Application Ref:	3/2021/0256	 Ribble Valley Borough Council www.ribblevalley.gov.uk
Date Inspected:	10/06/2020	
Officer:	RB	
DELEGATED ITEM FILE REPORT:		APPROVAL

Development Description:	Proposed single storey detached garage, front extension to adjacent porch, removal of three windows from kitchen and one from utility as a revision to the original planning consent ref 3/2020/0304
Site Address/Location:	7 Tennyson Avenue, Read, BB12 7RN

PROPOSED REAR ELEVATION

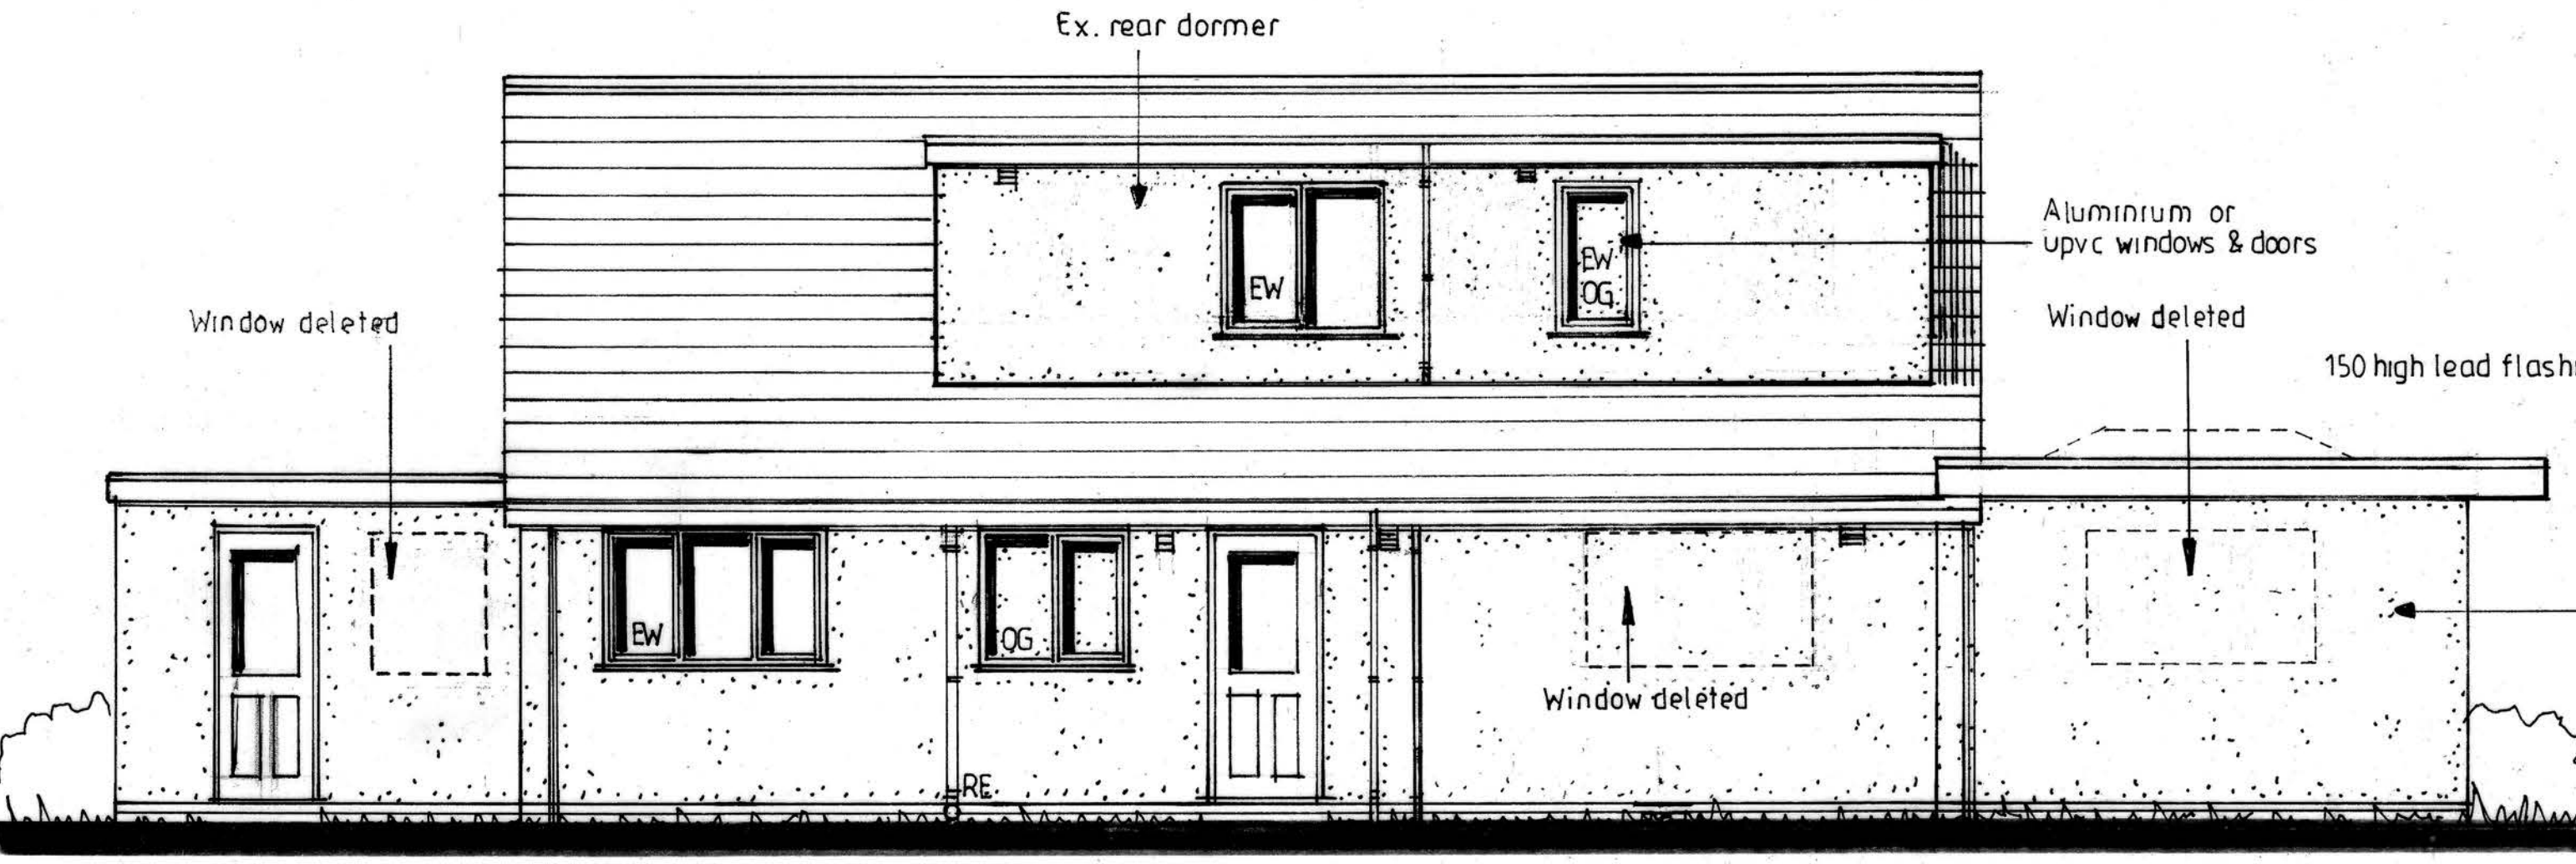
The development also proposes alterations to the previous approval ref 3/2020/0256. The amendments relate to the removal of new windows that were proposed to the kitchen and utility on the rear of the house.
